**KIRKLEES METROPOLITAN COUNCIL
TOWN AND COUNTRY PLANNING ACT 1990
HIGHWAYS DEVELOPMENT CONTROL KP20H**

PLANNING REF 2016/62/92319/E0/LC
CATEGORY Small Major

PROPOSAL ERECTION OF 10 DWELLINGS

LOCATION SITE OF FORMER ATLAS WORKS,
HALIFAX ROAD,
LIVERSEDEGE,
WF15 8HG

Client: D & M Middleton		
Project: Atlas Works Cleckheaton		
Drawing: Plot 1 & 2 Layouts		
Date: Feb 2016	Scale: 1:100 @ A3	
Drawing No: 1573/112		Rev: A

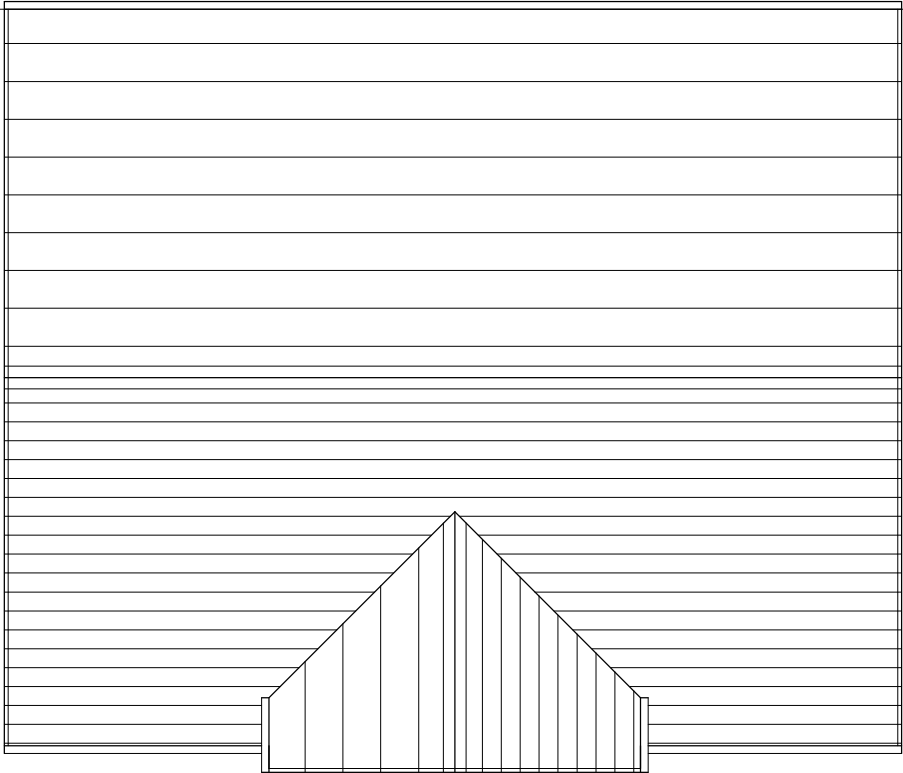
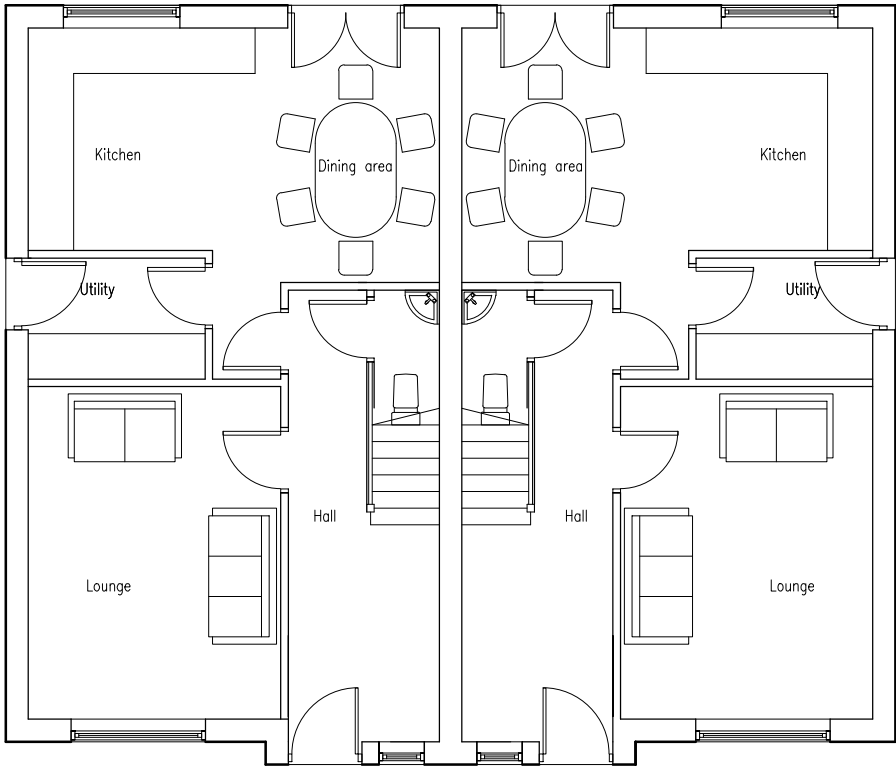
Plots 1 and 2 - Access to the parking to both plots will involve difficult turning and manoeuvre. Ideally an improved layout should be provided

Client: D & M Middleton	
Project: Atlas Works Cleckheaton	
Drawing: Proposed Site Sections 1	
Date: Feb 2016	Scale: 1:200 @ A3
Drawing No: 1573/122	Rev: B

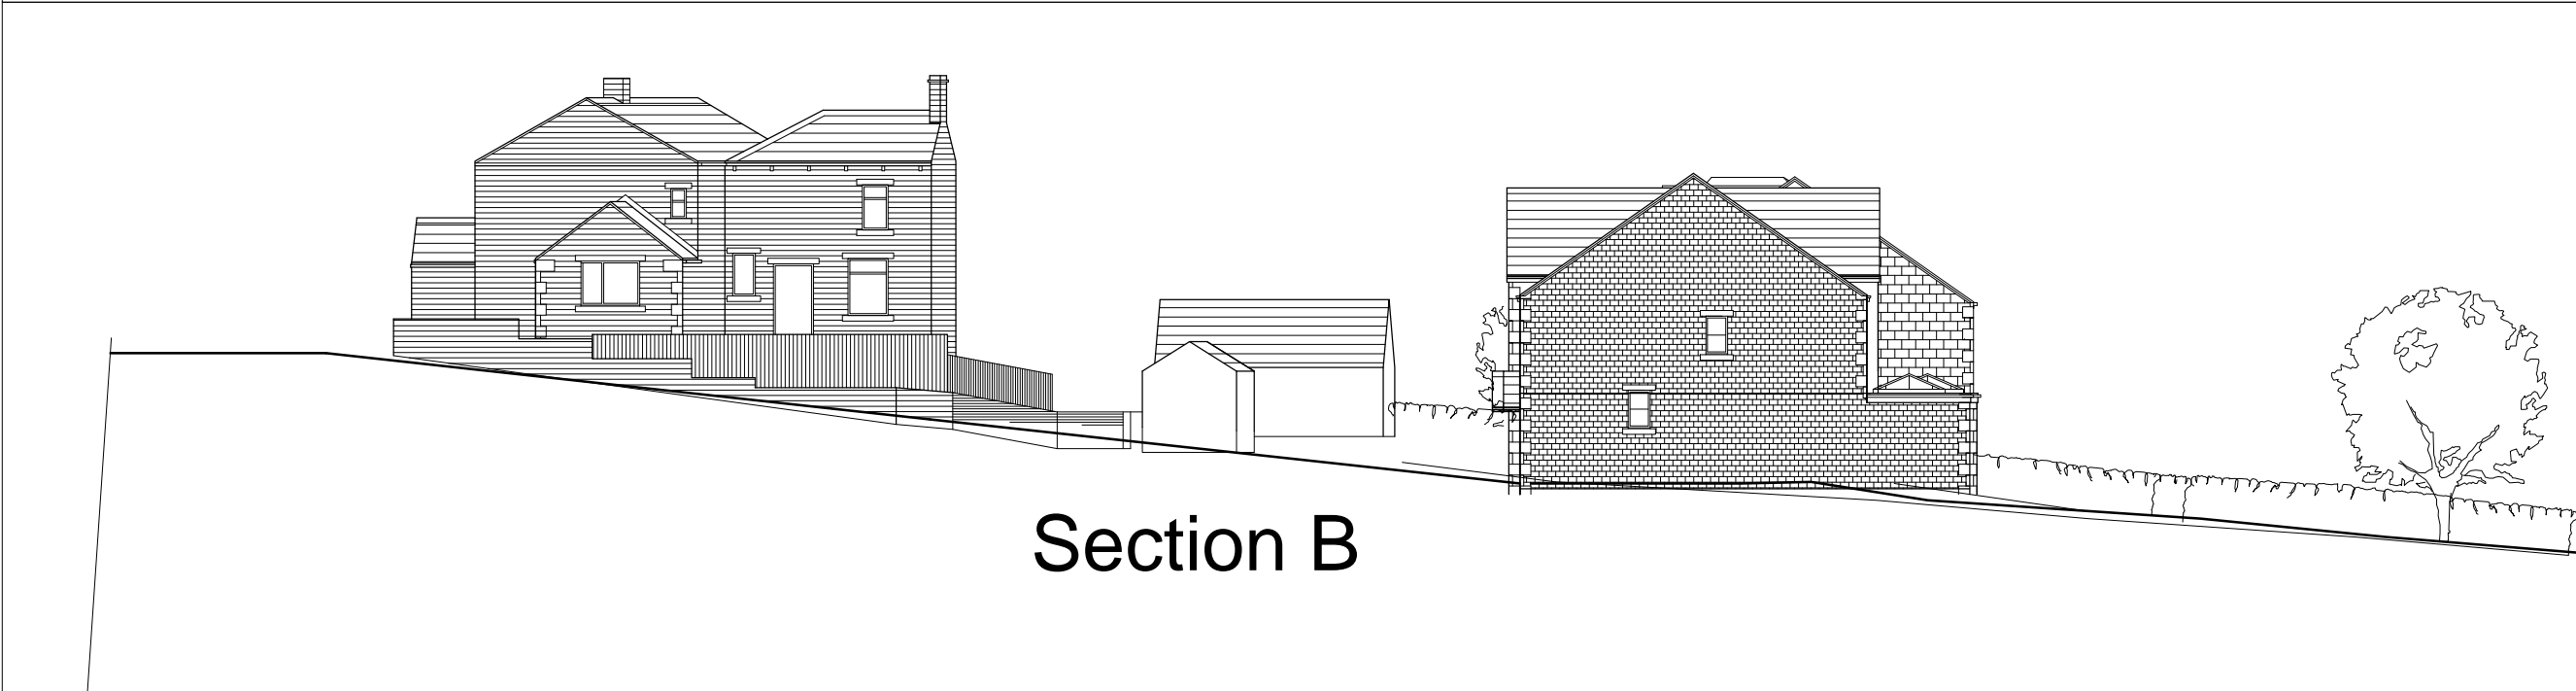
Gradients - The site falls steeply from Halifax Road into the site. Can the applicants provide longitudinal section through the centre line of the roads to demonstrate acceptable gradients can be provided.

Client:	D & M Middleton	
Project:	Atlas Works Cleckheaton	
Drawing:	Proposed Site Layout	
Date:	Oct 2016	Scale: 1:250 @ A3
Drawing No:	1573/110	Rev: C

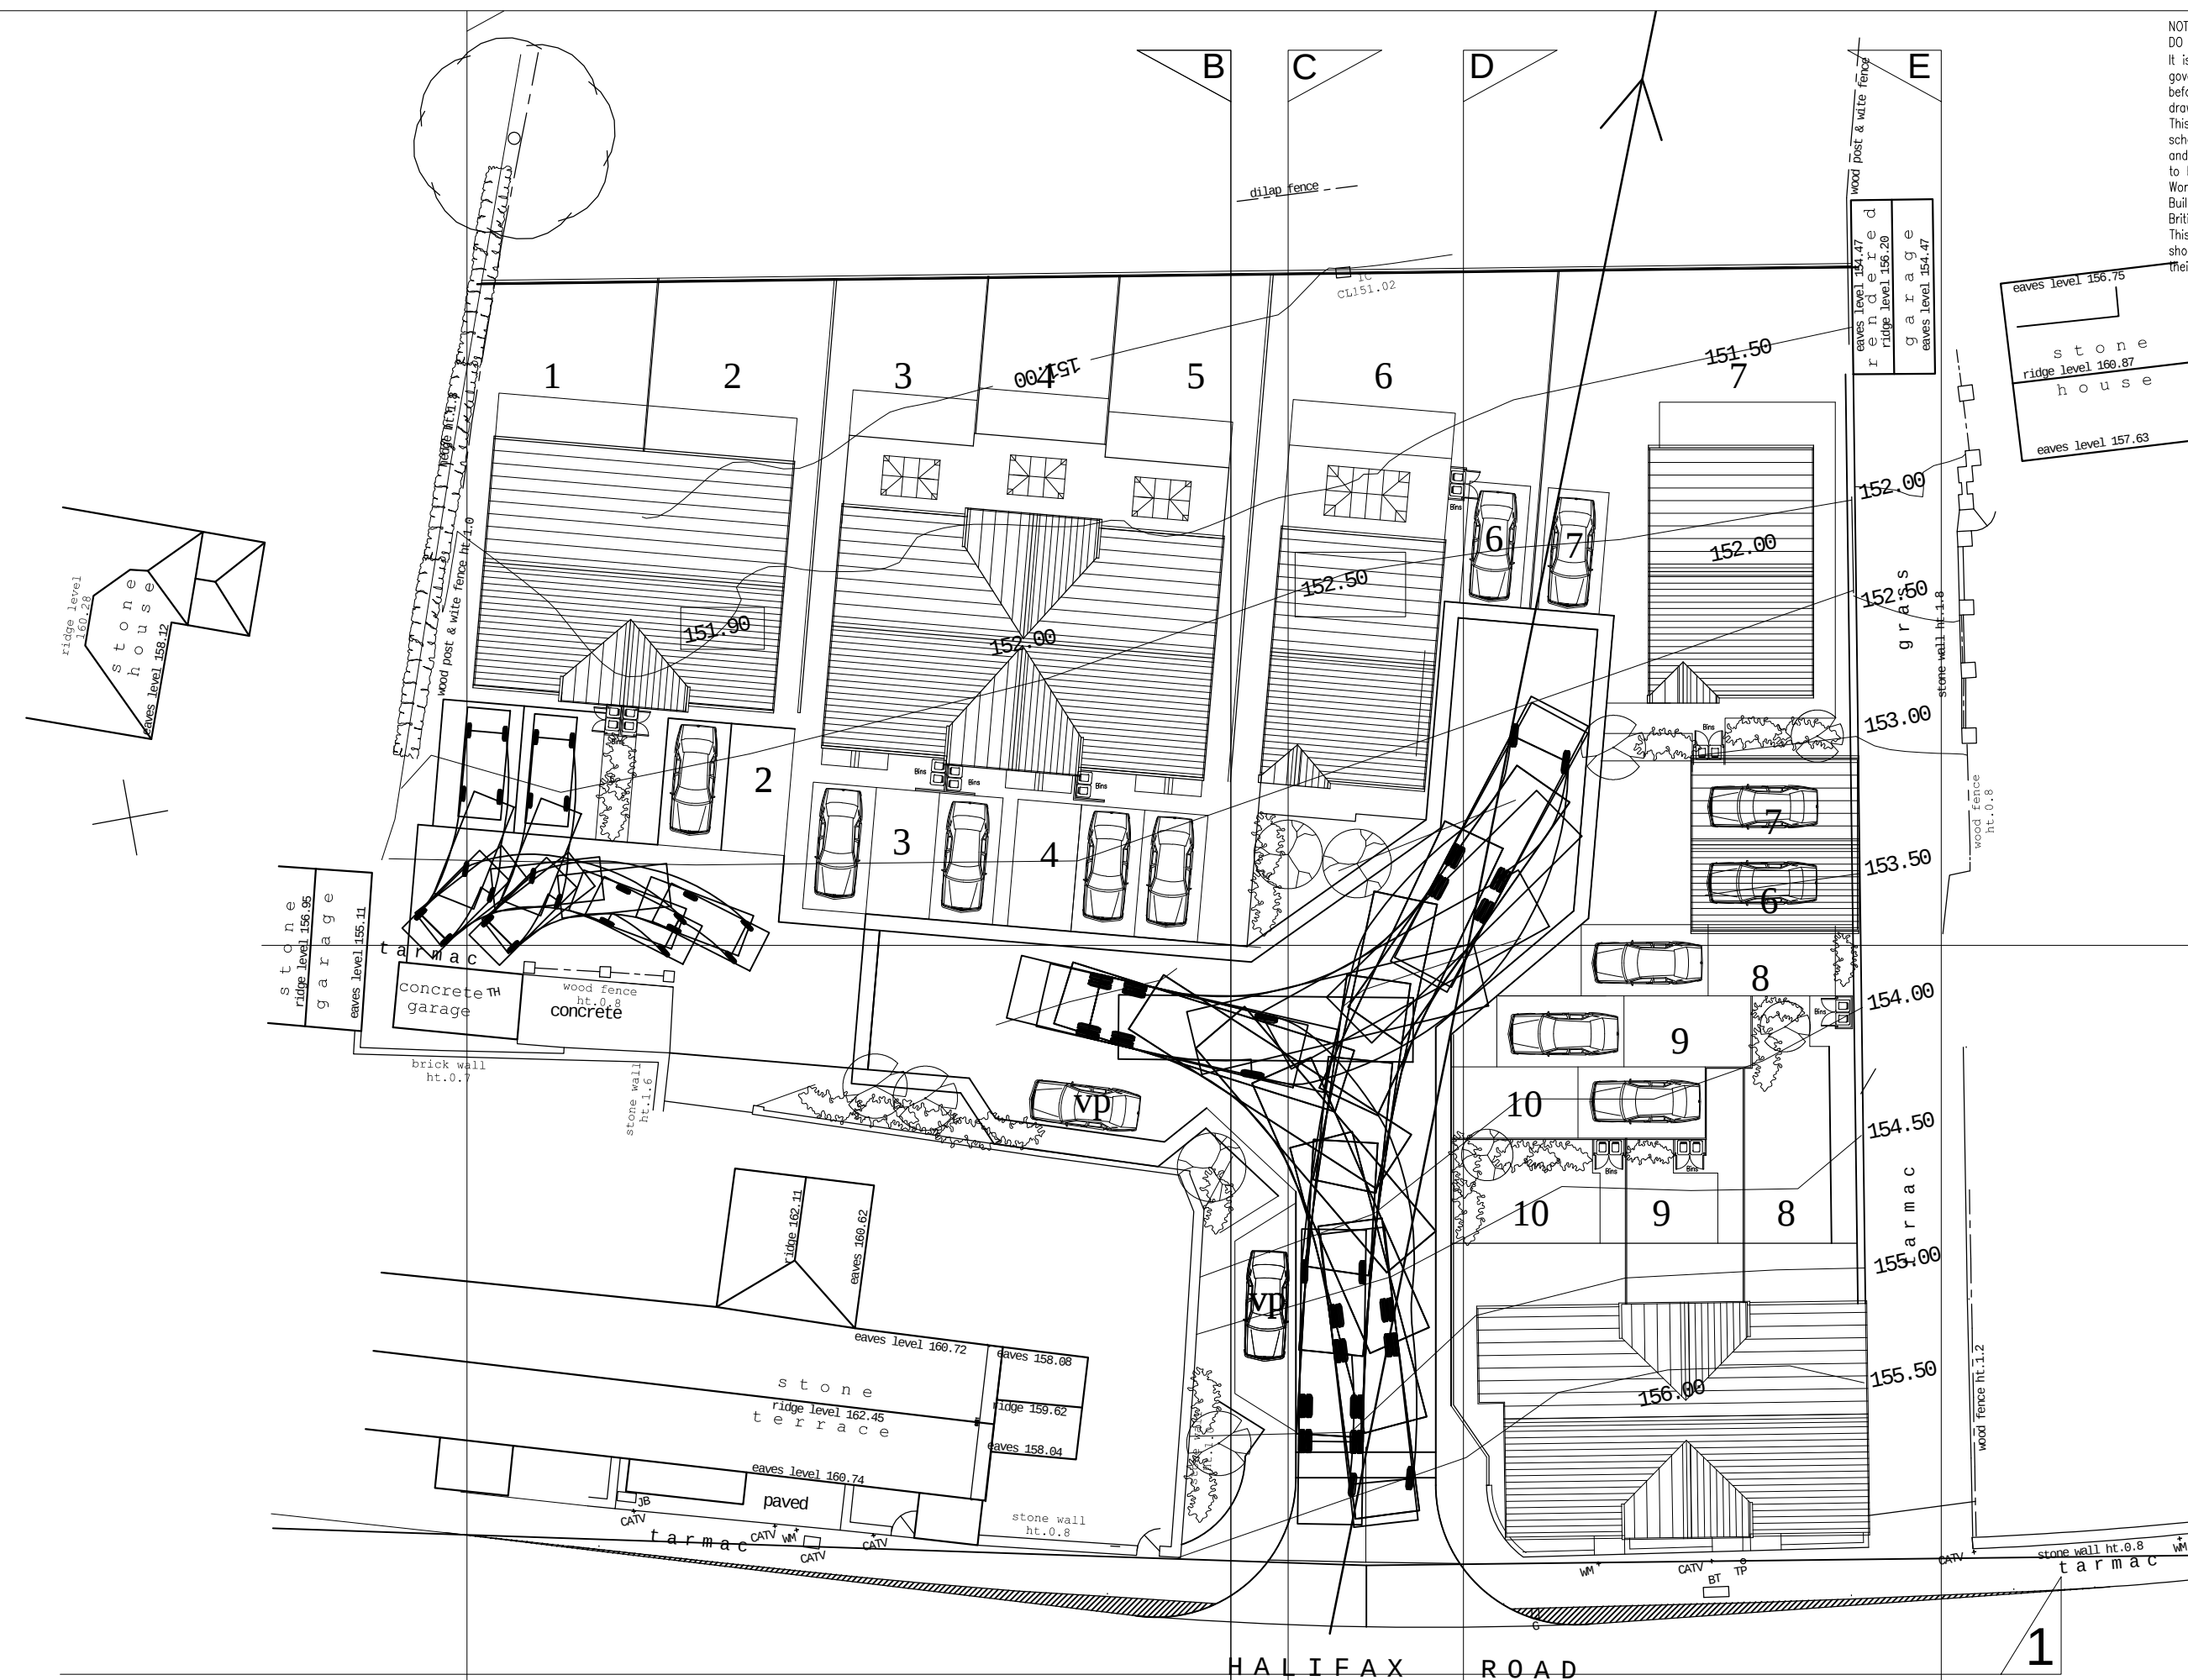
Plots 8 to 10 - There is no pedestrian access between the parking spaces to the rear. Ideally the spaces should be widened to 3.2m.

Internal refuse vehicle turning - The turning movement will be very tight and will involve difficult turning and manoeuvre. Ideally an improved layout should be provided.

Visitor parking - the parking space has shown scales only 5.0 metres in length at the rear. Ideally this should be 6.0 metres. Given the number of dwellings 2 parking spaces should be provided.

Traffic calming - A traffic calming ramp should be provided at the site access with the adjacent footways carried past to allow pedestrian access onto the shared surface.
